OUT19/16444

**Hanson Tweed Sand Plant Expansion (SSD-10398) (Tweed Shire)**

I refer to the above matter that was distributed to the Department of Primary Industries (DPI) for comment on Monday 25 November 2019.

**DRAWING TITLE**  
FIGURE 13: NORTHERN RIVERS FARMLAND PROTECTION PROJECT MAPPING

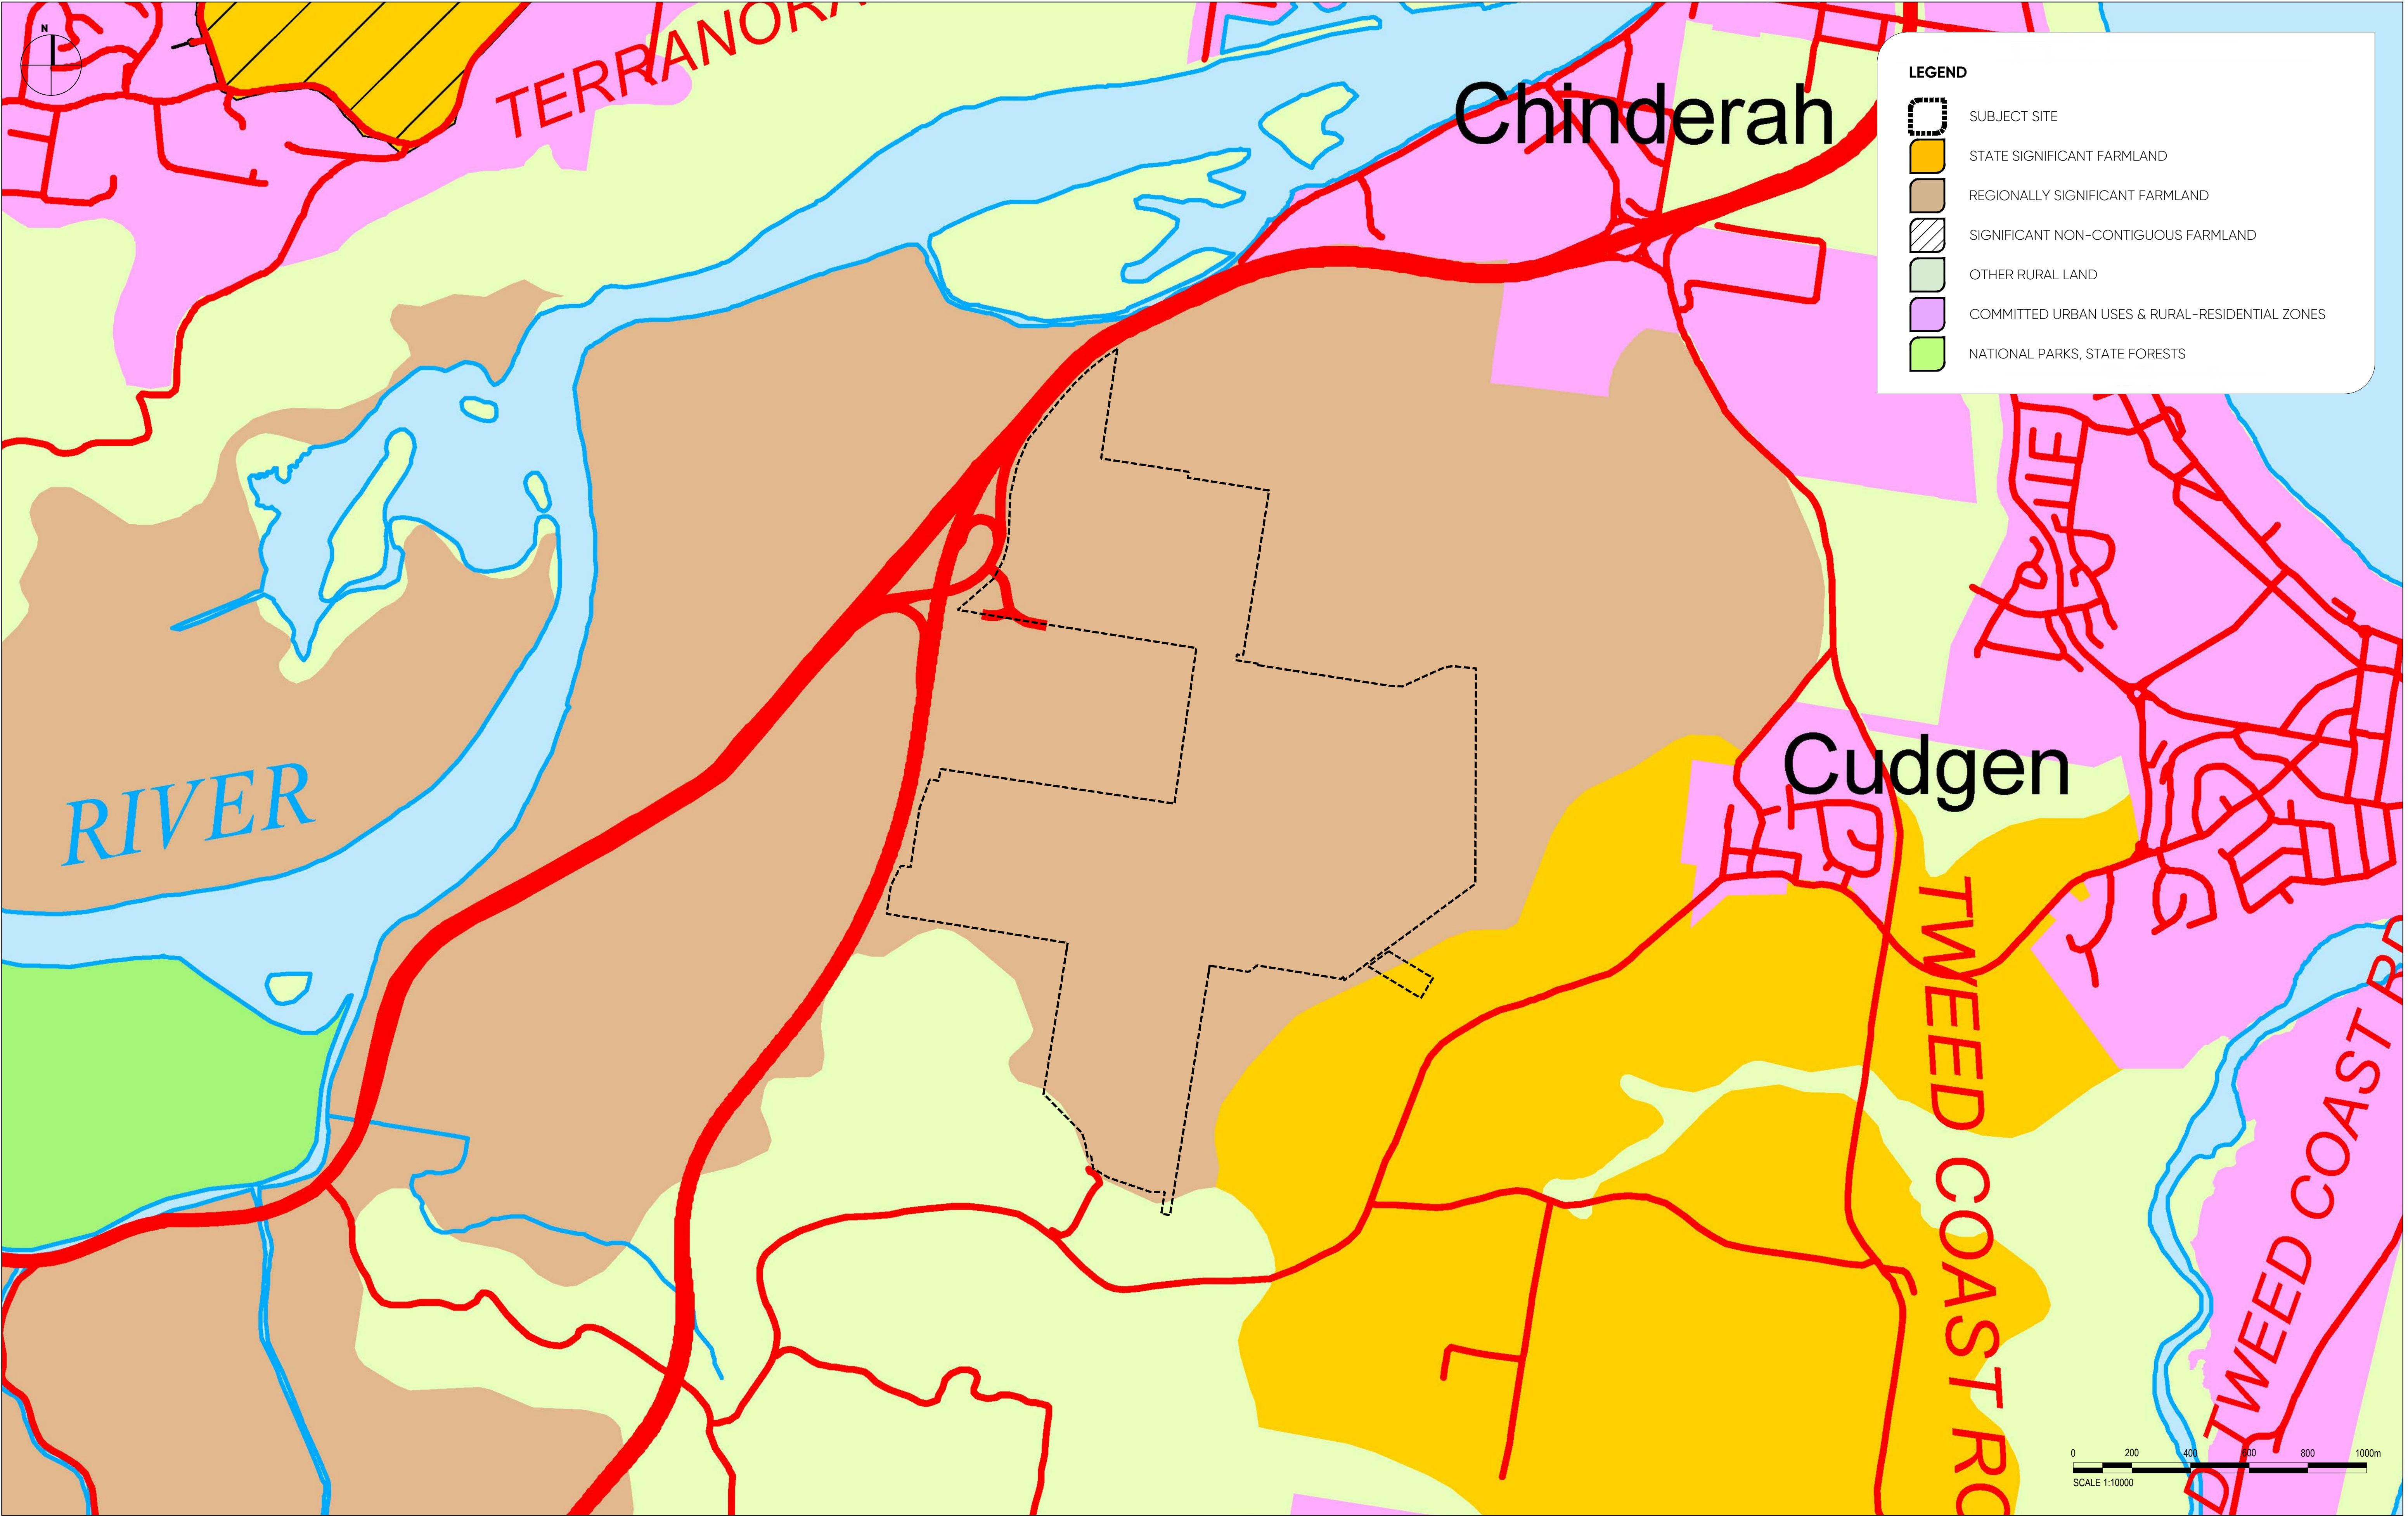
DPI is concerned with the protection and growth of agricultural industries and the resources upon which these industries depend. The subject land, as noted, is identified as Important Farmland (Regionally Significant Farmland), under the Northern Rivers Farmland Protection Project dated 2005. This is considered a highly important resource for agriculture on the NSW North Coast.

The farmland is part of a large contiguous agricultural land unit. Contiguity is important as it provides the opportunity for farmers to upscale or consolidate operations and reduces potential land use conflict risk that can impact on agricultural activities.
